Arun District Council
Arun Civic Centre
Maltravers Road
Littlehampton
West Sussex BN17 5LF
Planning & Building Control General Enquiries
Tel: (01903) 737756 Fax: (01903) 730442
Dx: 57406 Littlehampton
Minicom: 01903 732765
e-mail: planning@arun.gov.uk
website: www.arun.gov.uk/planning

Application No: P/42/22/DOC
Site Address: Land North of Hook Lane Pagham PO21 3PD
Description of works: Approval of details reserved by condition imposed under P/30/19/OUT relating to conditions 5-schedule of materials and finishes, 10-surface water drainage, 11-discharge flows to watercourses, 12-maintenance and management of surface water drainage system, 14-foul drainage system, 15-external lighting, 16-Construction Management Plan, 22-existing vehicular access onto Seftor Road and Pagham Road have been physically closed, 23-plans and details and timetable for installation of dwellings, 24-pedestrian and cyclist access points, 27-Broadband provision, 29-enhancement of existing hedgerows for use by bats and 33-Electric Vehicle Charging Strategy.

Thank you for your internet representation made on 29th March 2022 which has been recorded as an objection with the comments as follows:

job/dwg no.	rev.
167-RM-23	-

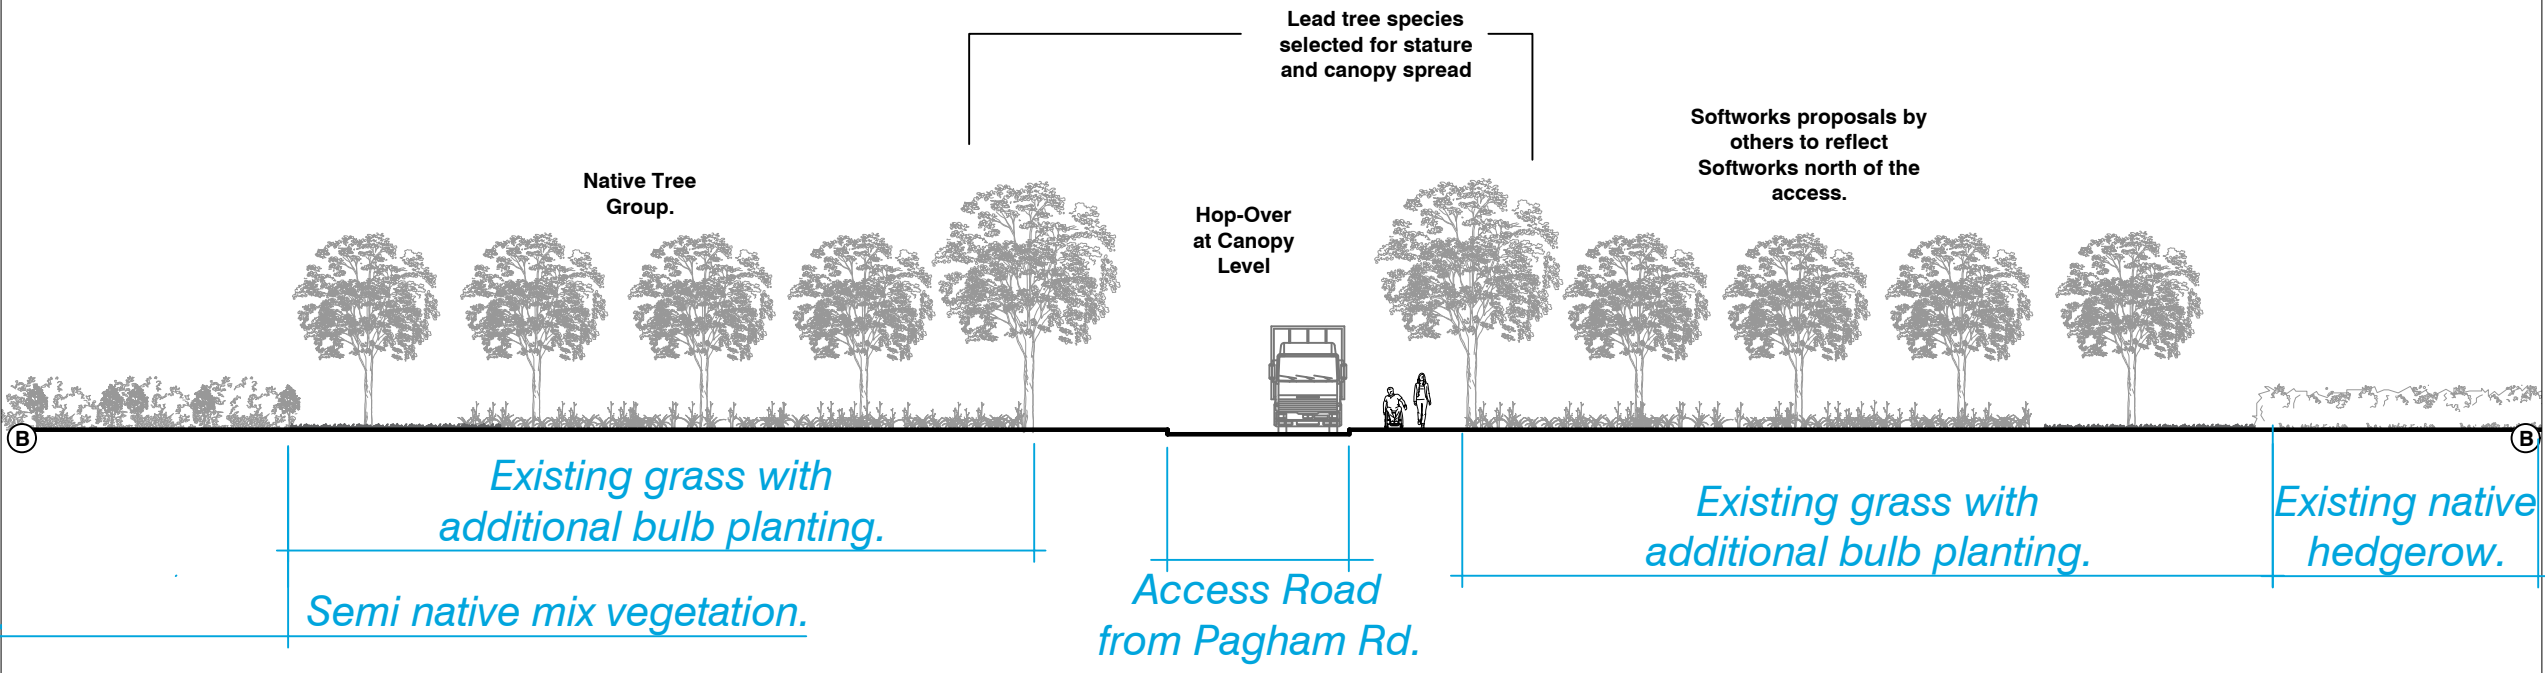
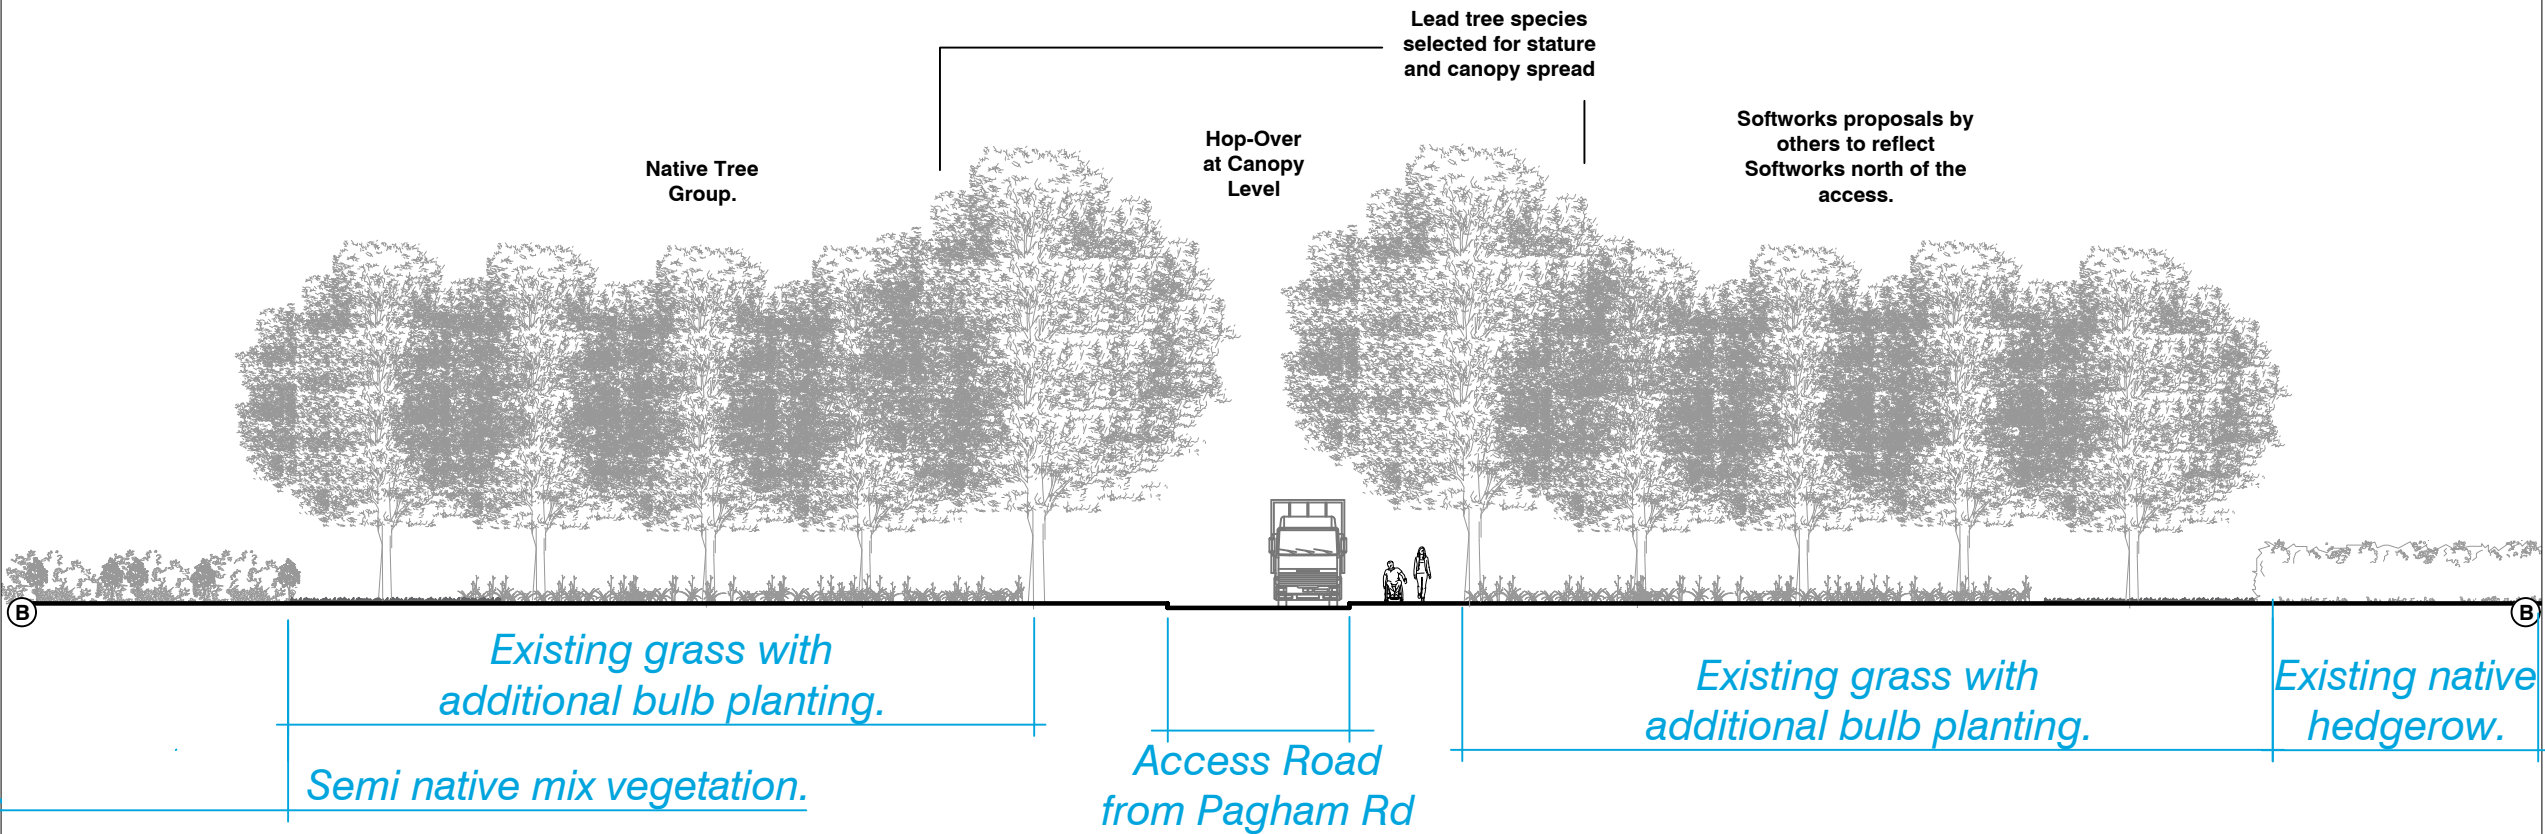
I've noticed a contradiction between the Access Arrangements onto Pagham Road (approved under application P/13/19/OUT) and the Soft works Schedule included in this application (which is broadly the same as what was approved under P/132/20/RES).

The approved access arrangements for this planning application were based on the vehicle speed data and required a visibility splay to the north of 4.5m x 149m.

The Softworks schedule however has designed the softworks planting for that junction based on a 30 mph limit. (FYI the road is currently a national speed limit road). This means that the Hop over areas, Woodland Planting and the hedge are not allowing for the full 149m visibility splay. The Council have confirmed to me that the 149m visibility splay is the correct one.

The impact of this means that the following drawings are at odds with the approved Access Arrangements onto Pagham Road (approved under application P/13/19/OUT):

- Southern Access Hop Over Sections 167-RM-23

I believe it is important this is clarified and corrected since the Pagham Road entrance seems to be the only entrance to the site for the construction and therefore needs to be correctly designed (with 149m visibility splay) from the outset, or else that part of the road will be even more dangerous than it currently is.
